Our Ref: R/2016/15/H
File No: 2022/230025
Your Ref: SSD-7610-Mod-5

**Advice on Modification Report
Inner Sydney High School – SSD-7610 Modification 5 – Façade Lighting**

Modification 5 seeks consent for lights that have been installed on the northern, eastern and western facades of the newly constructed 13 storey Inner Sydney High School building.

2.1 Simulation Results and False Colour Rendering

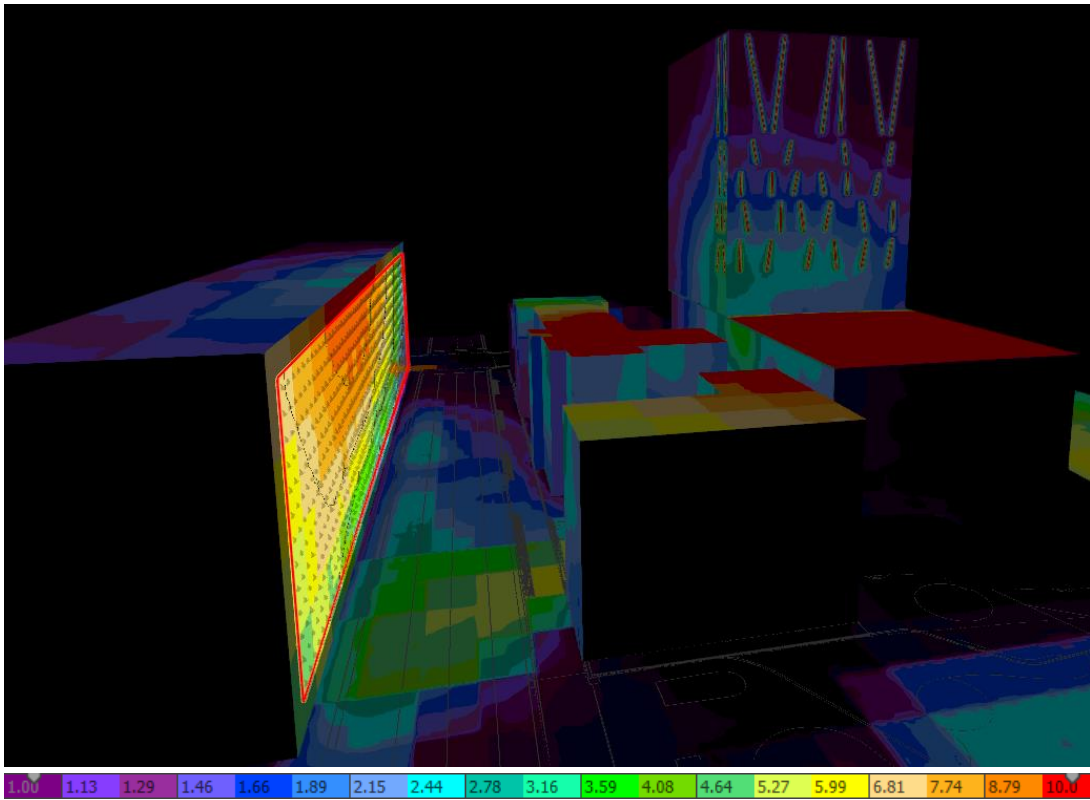
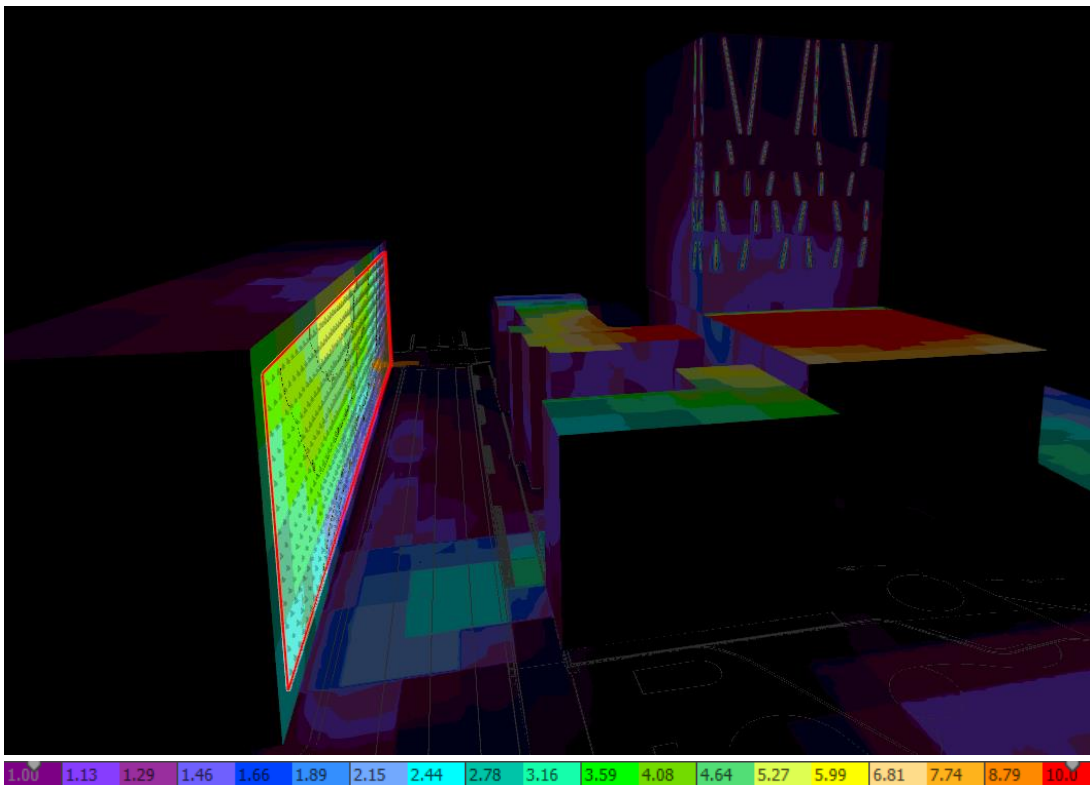
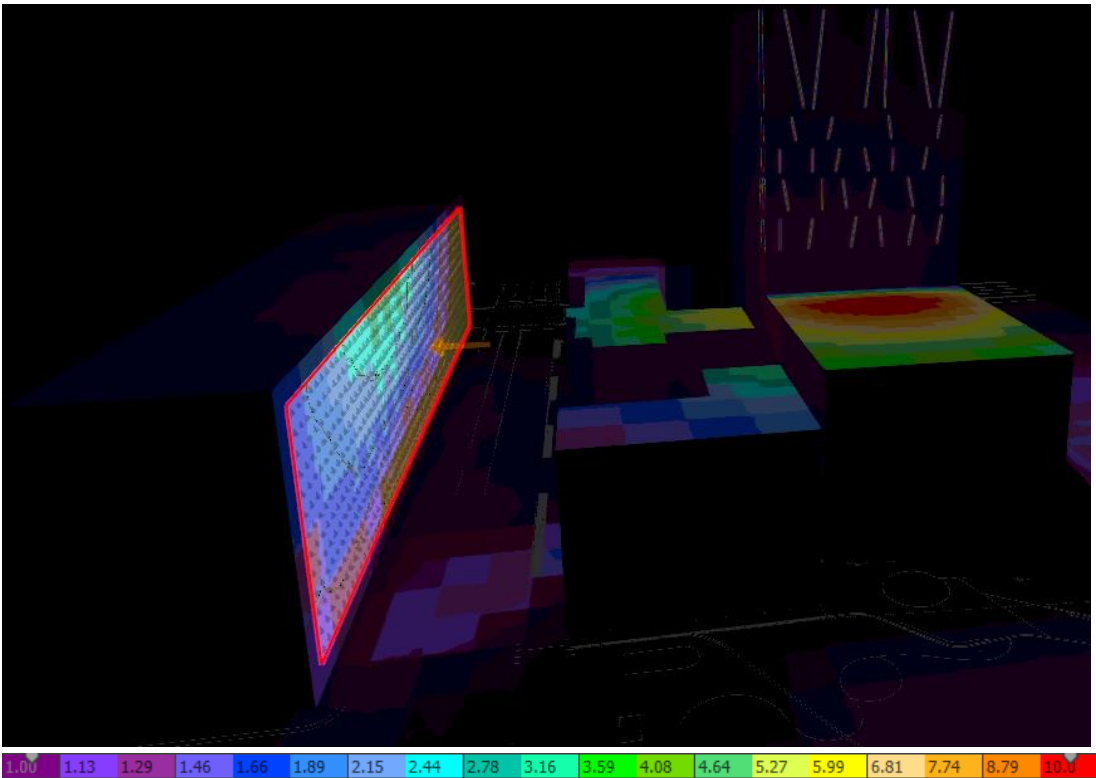
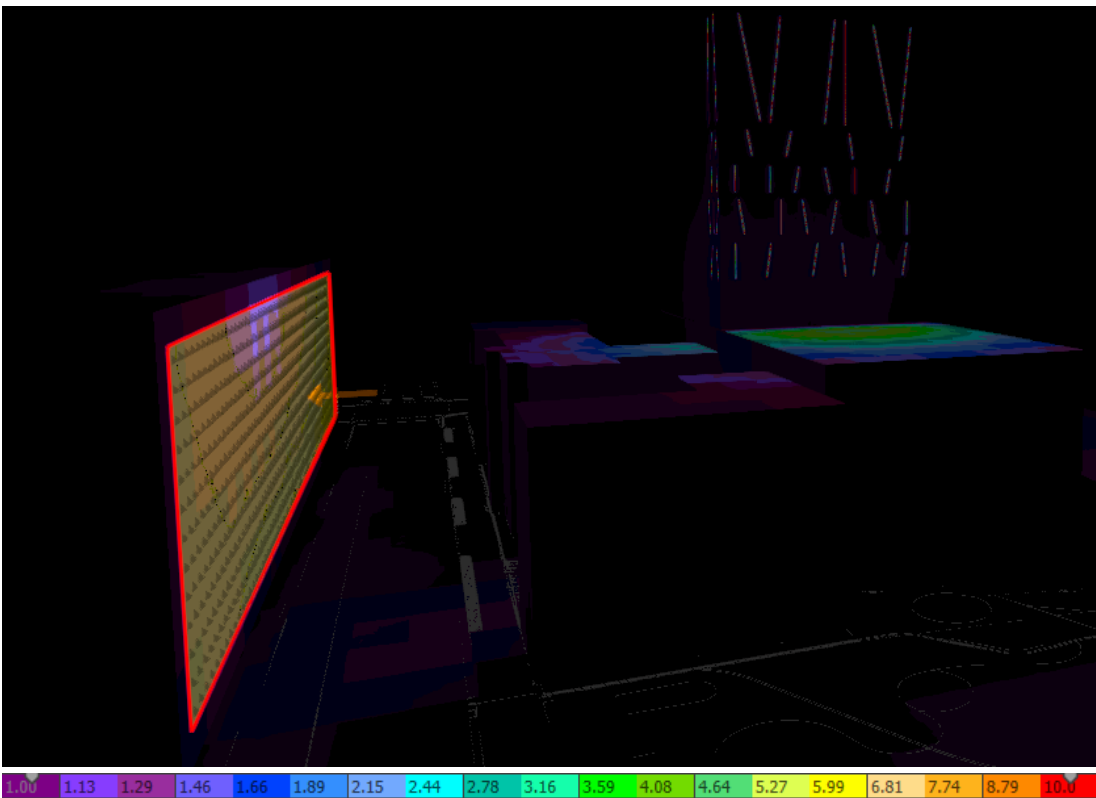
The proposal has not adequately demonstrated compliance with the objectives and provisions of Section 3.2.8 – External Lighting in the *Sydney Development Control Plan 2012* and the *Exterior Lighting Strategy 2005 – Section 7.2*. The submitted lighting report is considered to be incomplete for assessment purposes. The following information is requested:

- Illumination designs, certified by a suitably qualified practising lighting engineer, confirming compliance with the following specifications:
 - Illuminance along opposite residential properties as per *AS4282:2019*
 - Calculations for spill light into the sky
 - Calculations for luminance of luminaires
 - Calculations for luminance of lit façade
